Subject: Invalid Letter 21/01543/F

Rev	Date	Description	Drawn
A	11.08.21	Patio door to dining omitted.	MAS

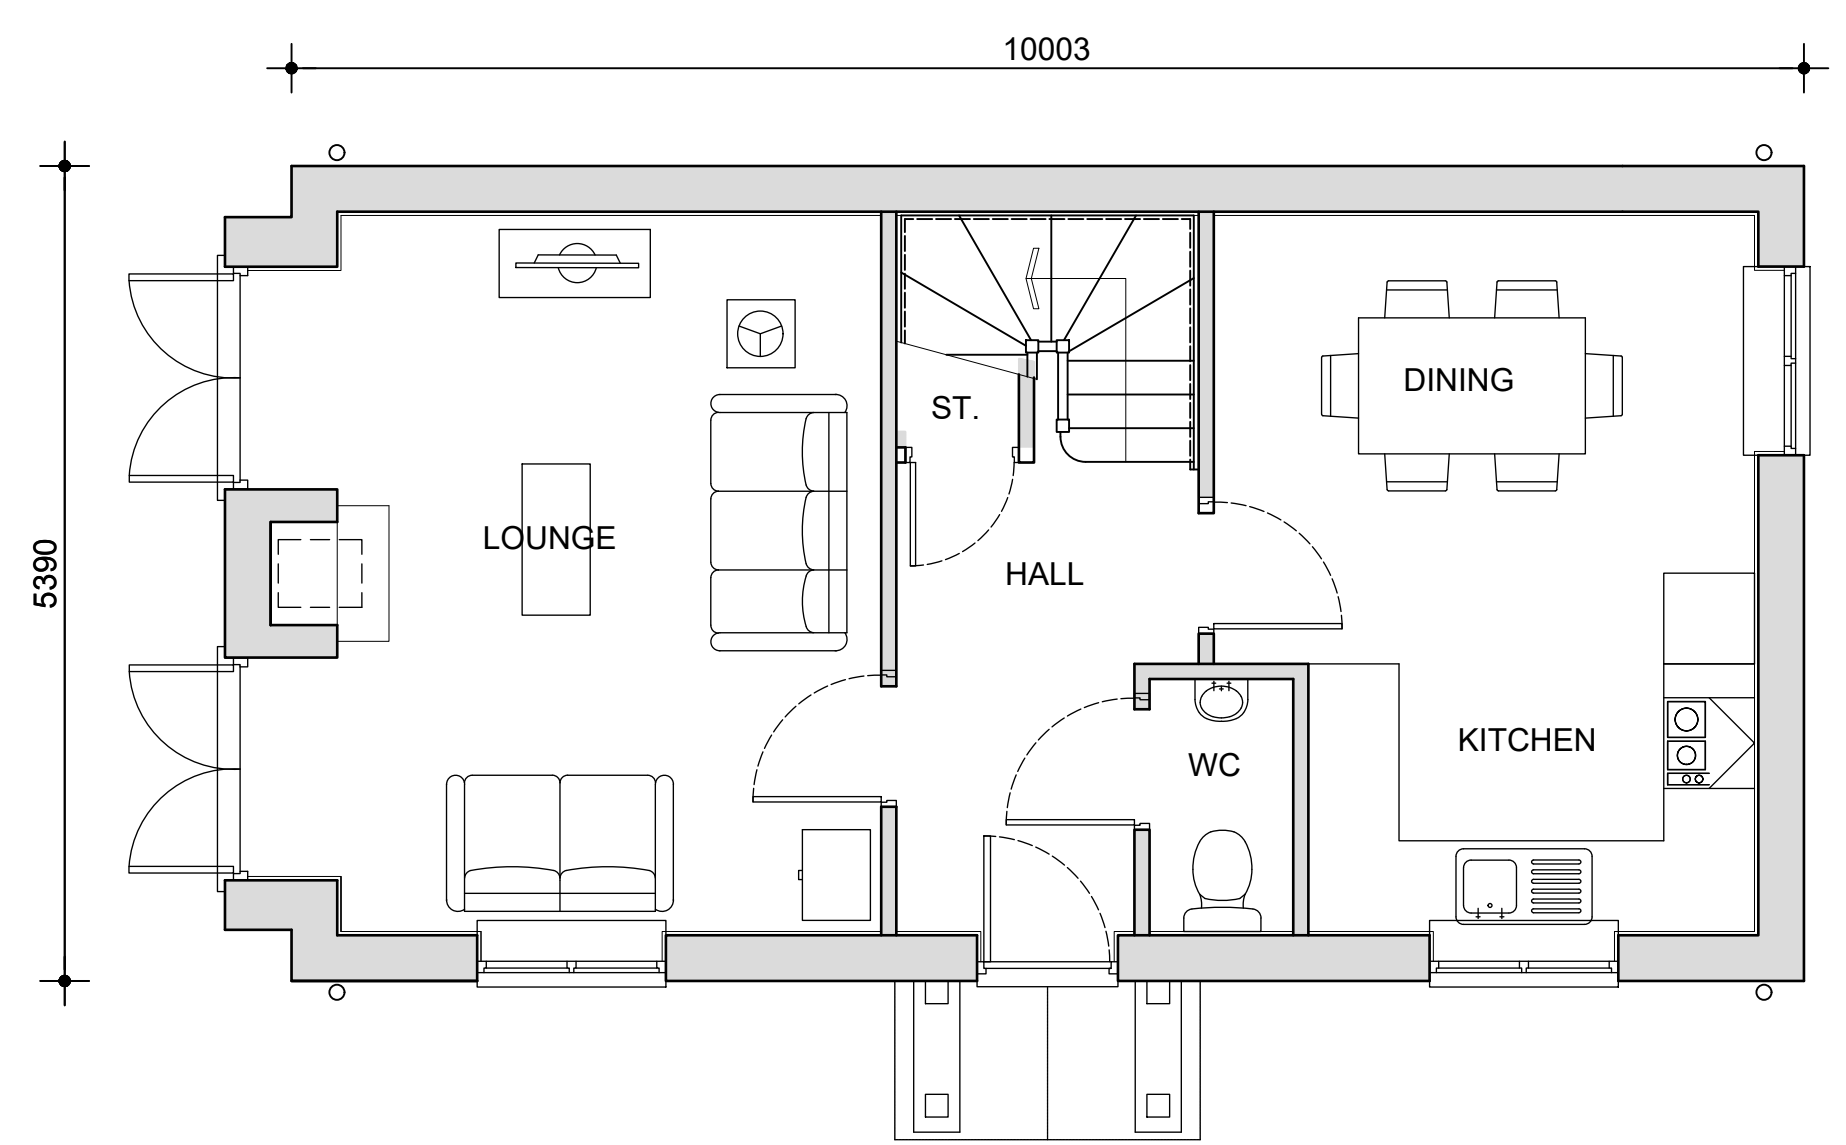
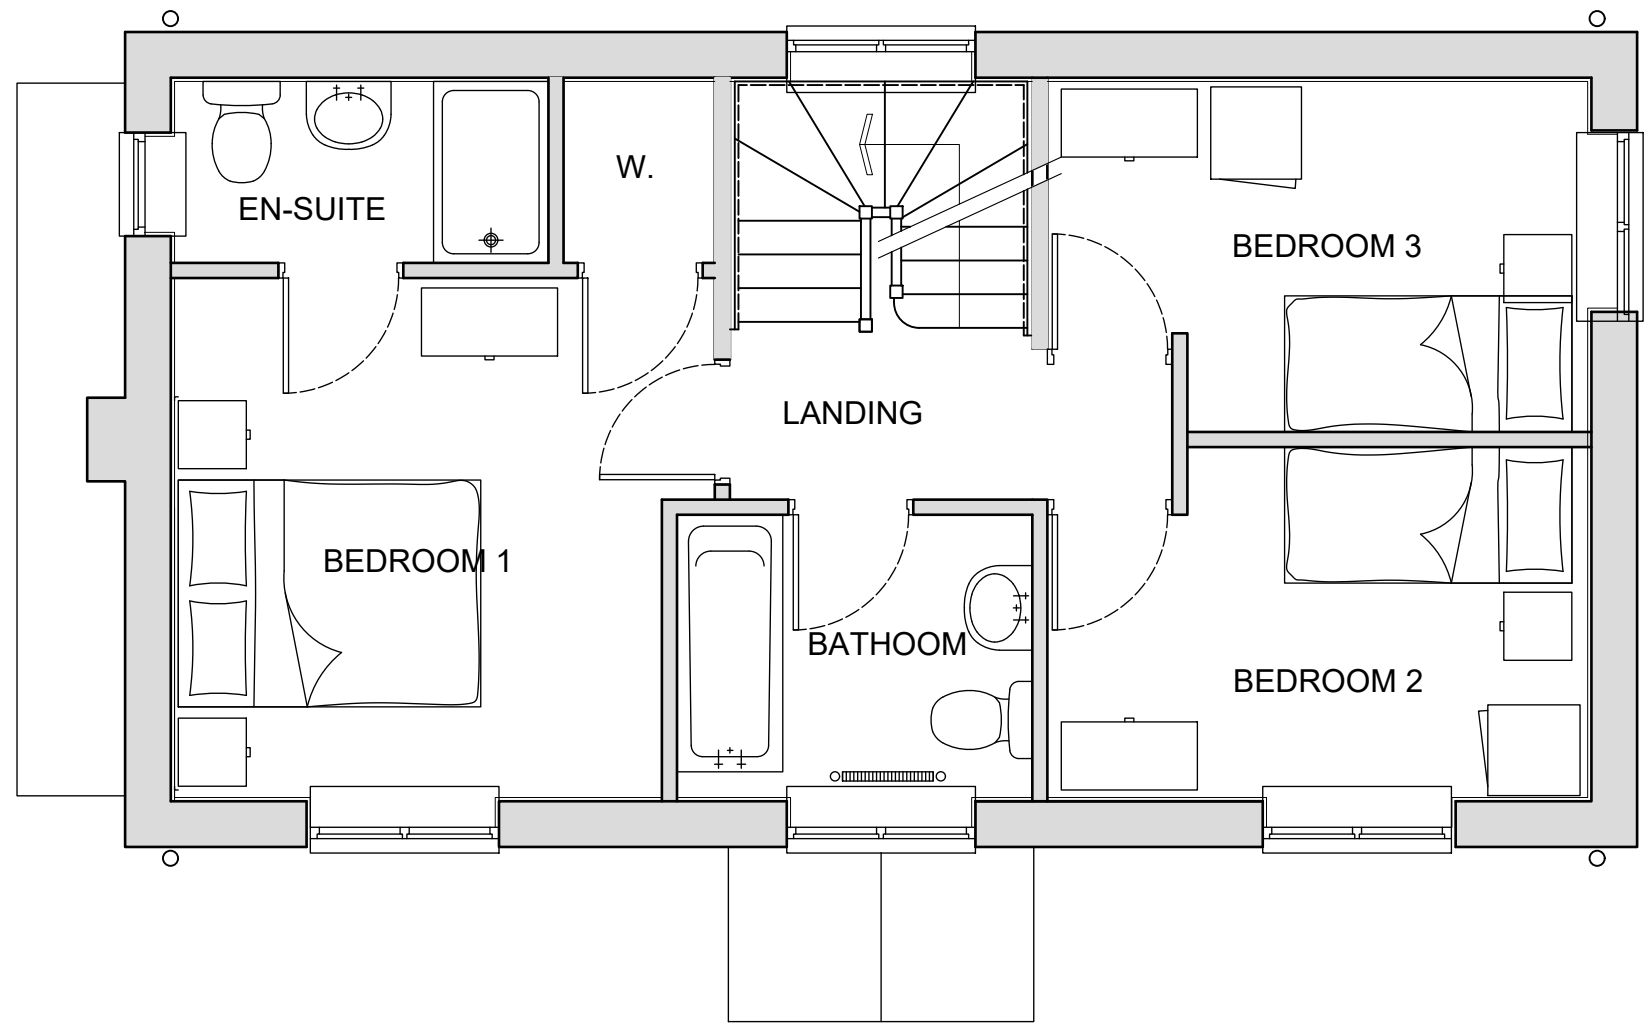
1. Contaminated Land Questionnaire (unfortunately, this wasn't attached to your email as stated?)
2. Habitat Fee (refundable on request, should the application be refused)
3. Flood Risk Matrix (editable version attached).
4. Section-through new dwelling
5. Item 7. On my colleagues email (slight error on the proposed ground floor plan)
